RE:Planning Application R/94/19/PL Rustington Convalescent Home

I am writing to you with concerns on the proposed new planning application regarding the changes to Block F of the Rustington convalescence home proposed complex, new revision R94/19/PL changing the approved application from 2 x 2 bedroom Chalet style semi-detached properties to 2 x 3 bedroom semi-detached properties.

NORTH ELEVATION
Scale: 1 : 100

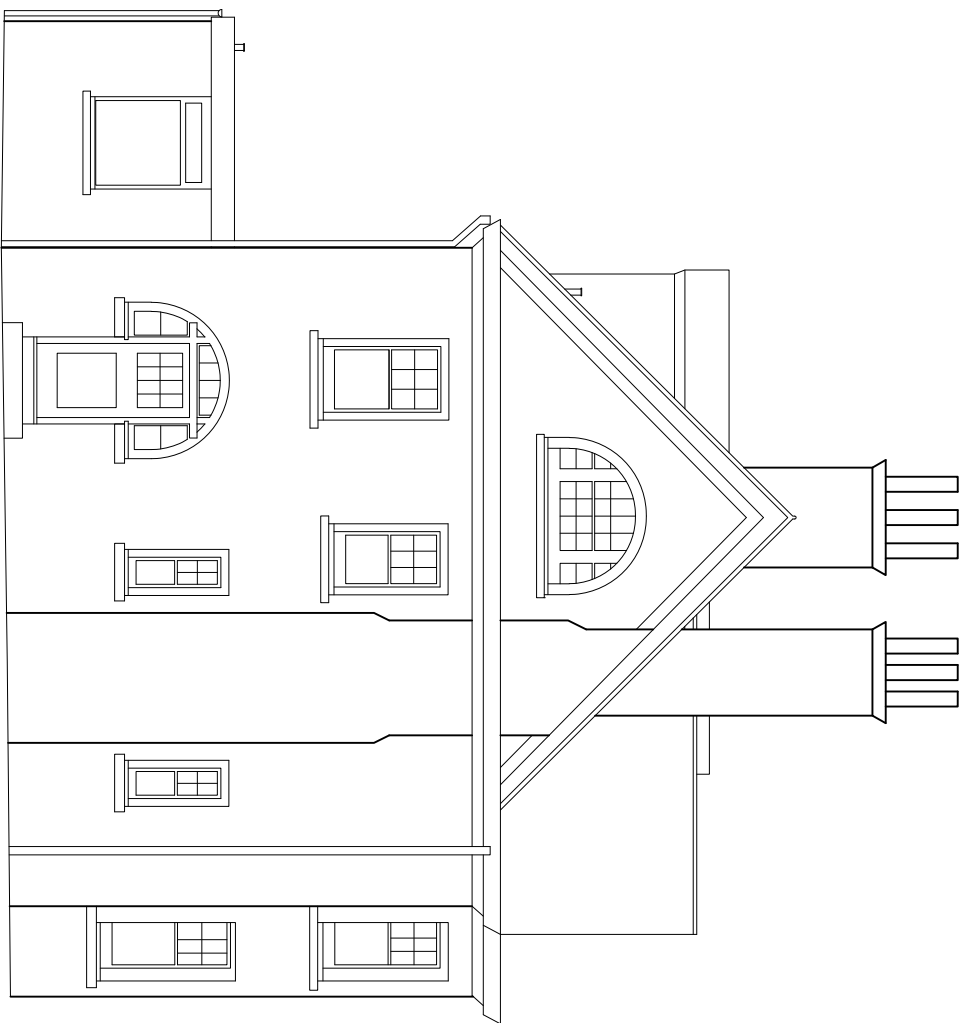
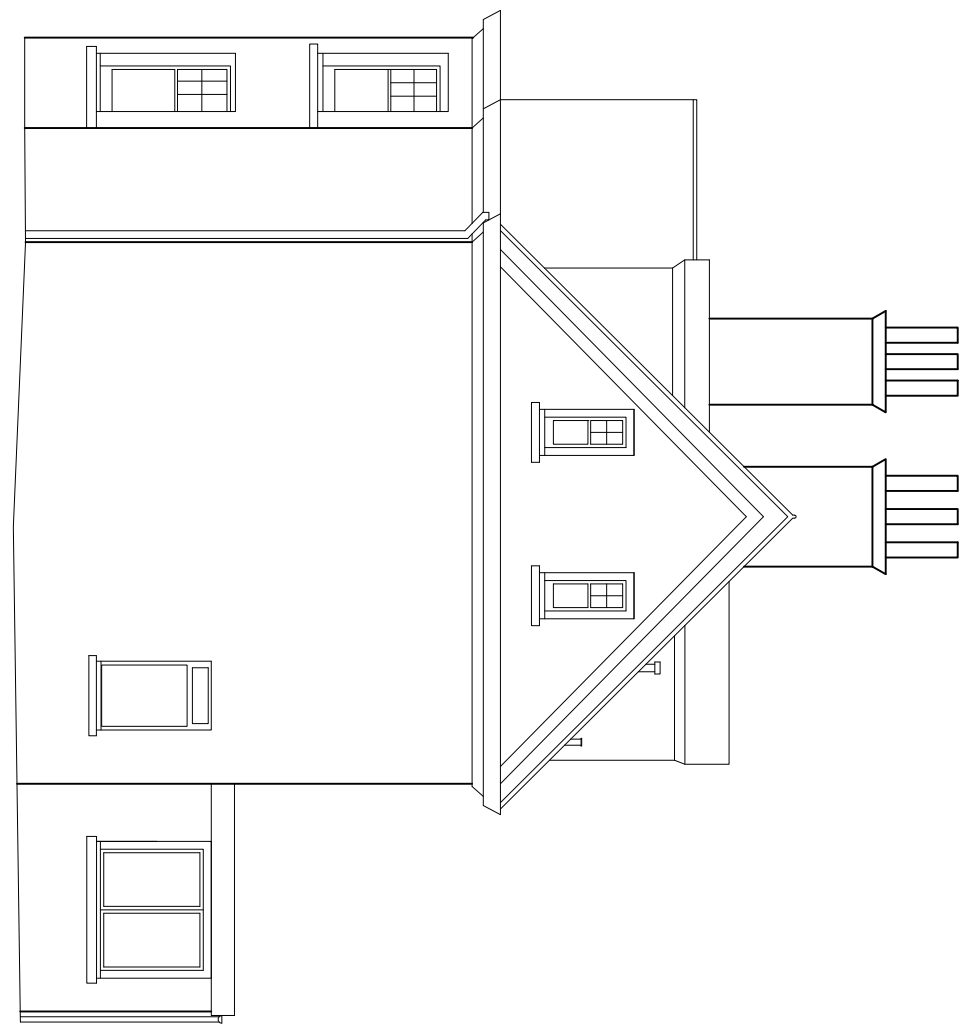
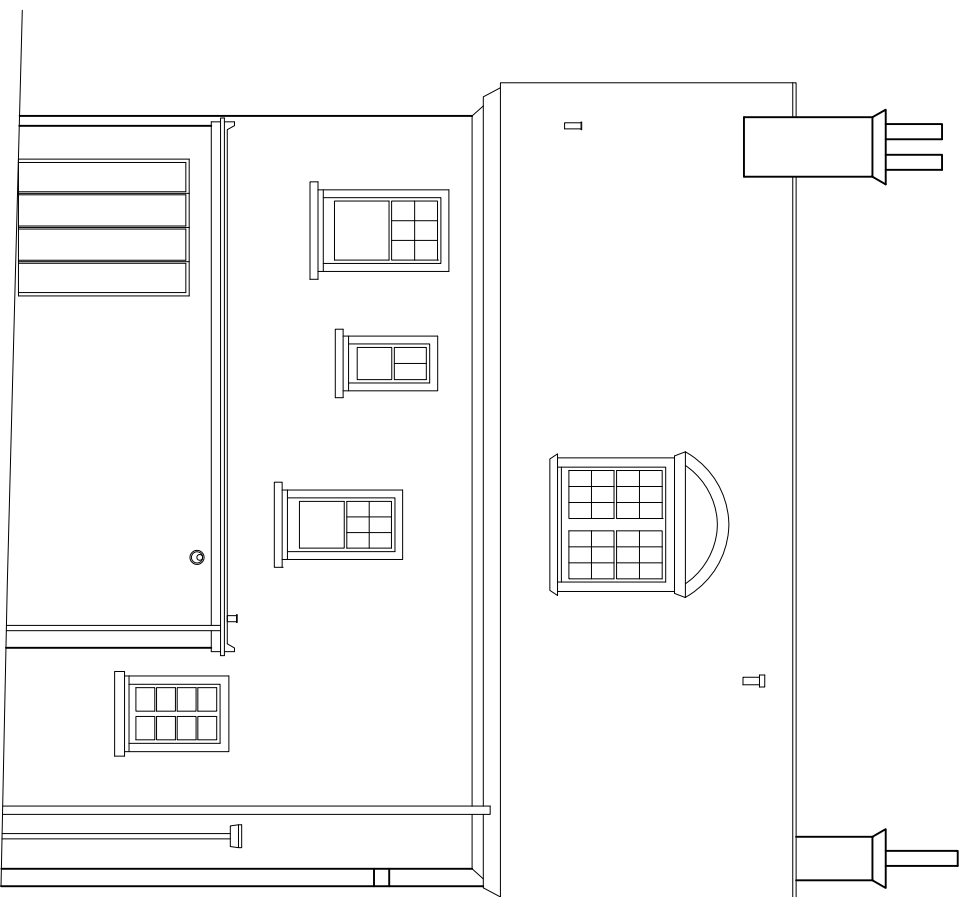
The new proposed application is a complete change to the original plans as Block F now shows 2 x 3 bedroom larger semi-detached family style properties with plans to place windows to the first floor rooms so that all of the existing properties will now be overlooked to the North & East elevations. Number 34 will be over shadowed as the

plans show a very high brick gable wall to the side elevation, also number 32 will have all the windows looking straight into their property giving them no privacy at all. The remaining properties will also be overlooked.

The proposed development by reason of its proposed size, depth, width, and now height and massing would have an unacceptably adverse impact on the properties immediately next to adjacent to the site and the surrounding area by reason of overlooking, loss of privacy and visually overbearing impact.

FIG. 57 - PROPOSED BLOCK E AND F

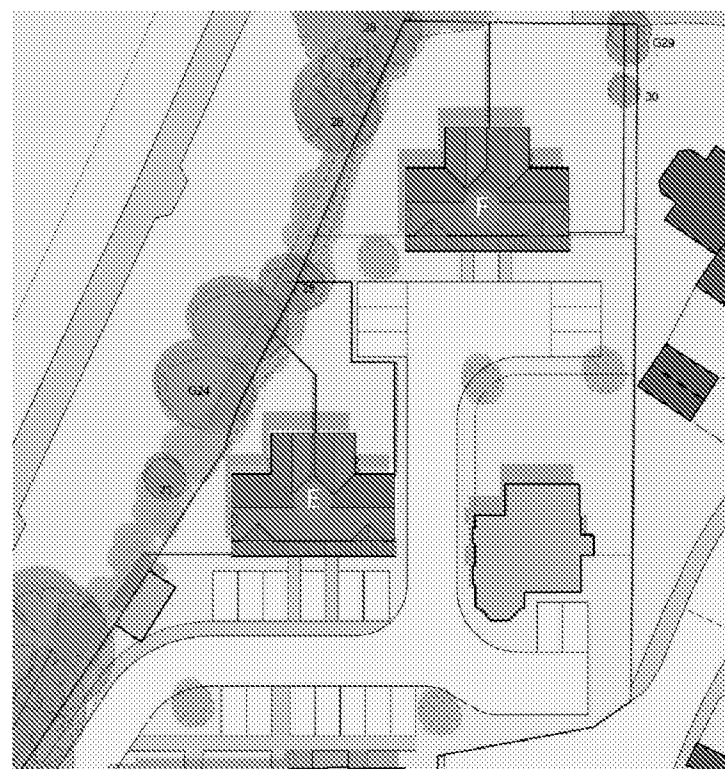
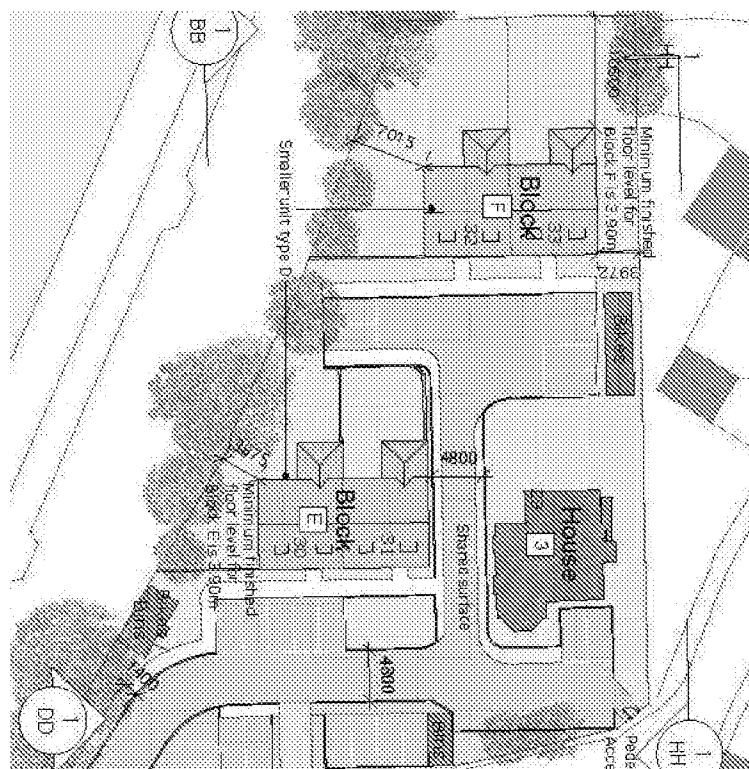
With this in mind I ask you to really consider if block F on these new proposed plans are being over developed for financial reasons rather than what is best for the small plot and for those who live in the surrounding area.
